SSD-66826207 – Fiveways Site including affordable in fill housing.

Submission from: Prof Geoff Hanmer (Reg Architect 5147 NSW) and Jo Mausolf.

Geoff Hanmer and Jo Mausolf object to this submission:

Figure 3: 78.05m Height Plane Diagram (Source: Turner)

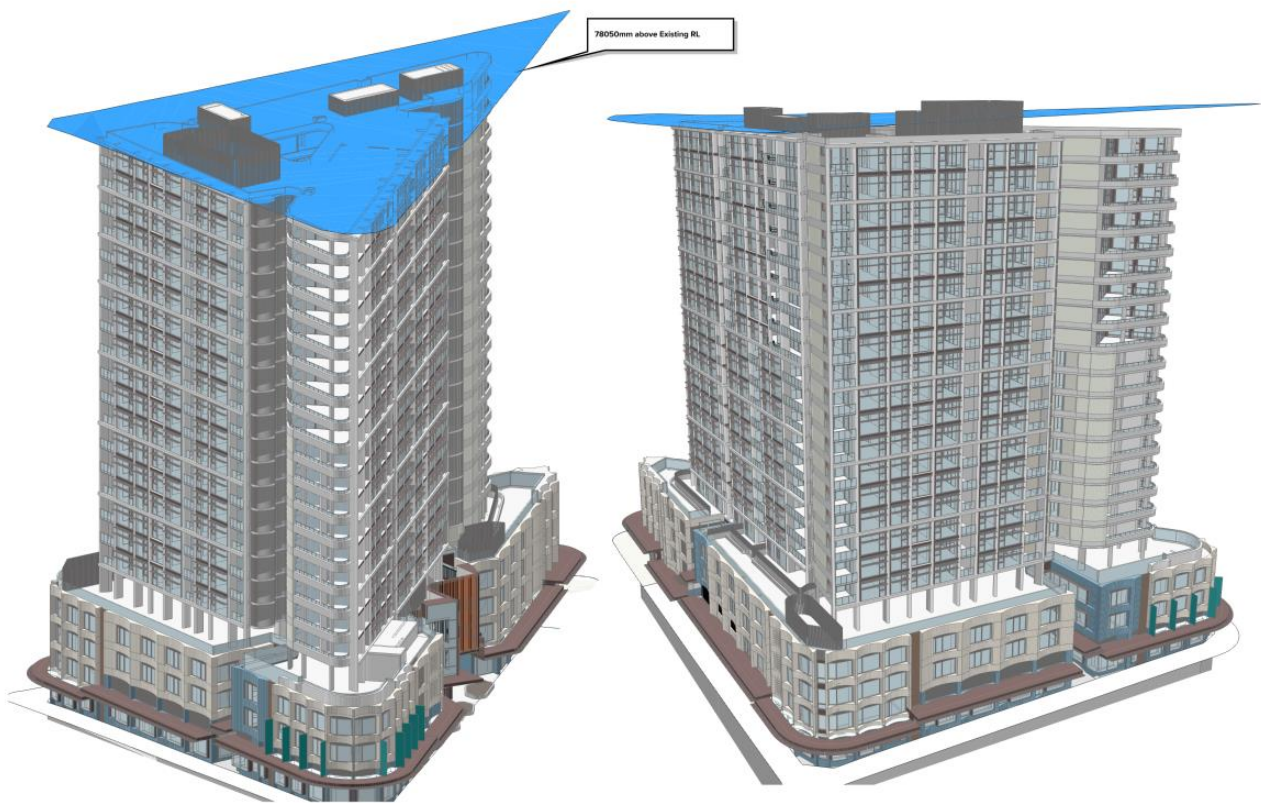
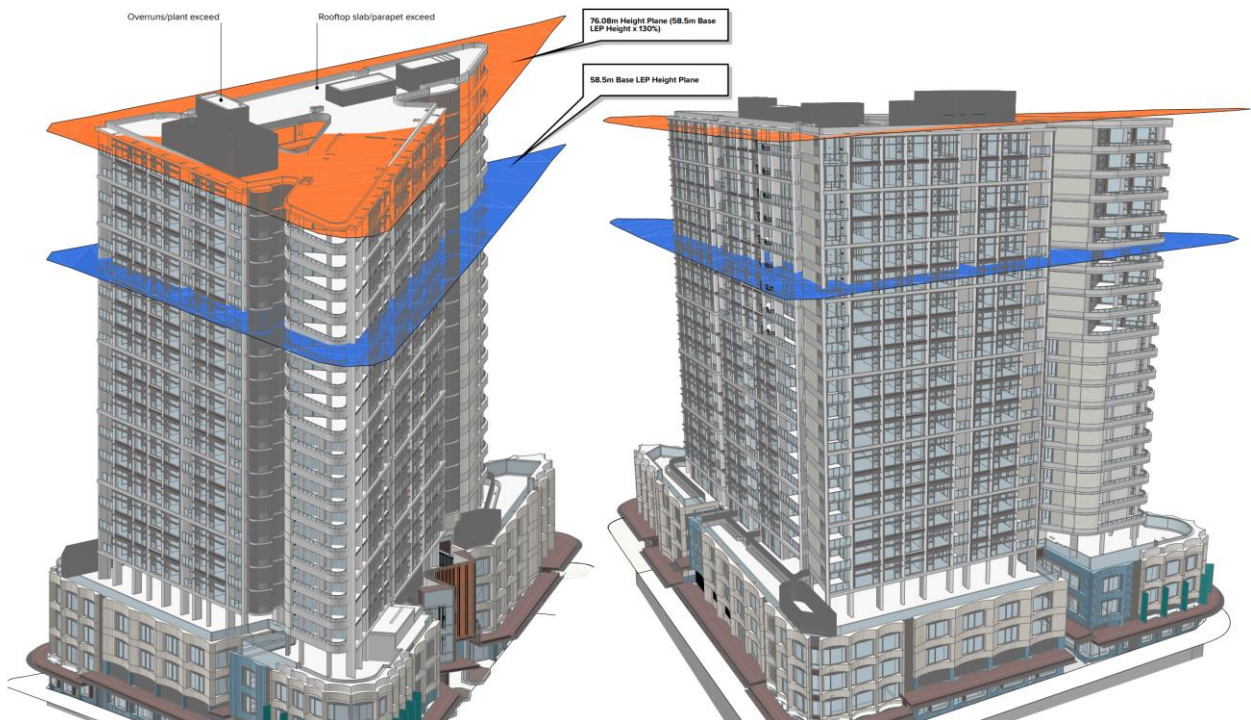
For the SSD application, the increase in height by four floors at 3.100 metres/floor would be 12.400 metres and the maximum allowable height for the new SSD application would be 58.5 + 12.4 = 70.9 metres (RL 169.00).

The 7m difference between maximum allowable height and the applicant's proposal can be seen in the new podium design. The bonus provisions of in-fill housing does not give license to the applicant to make other changes that push the height beyond the maximum height allowable.

The SSD Application does not comply with this Section 18.

The maximum height also using the more logical interpretation of the SEPP would be 4 floors equal to an extra height of 12.4m, thereby lifting the maximum height from 58.5m to 70.9m (RL169.0).

The podium, which has increased height in this new proposal compared to the height incorporated into the already approved proposal, would need to be amended. The bonus provisions do not give license to the applicant to make major changes to any part of the design that push the height above the maximum allowable under the bonus policy.
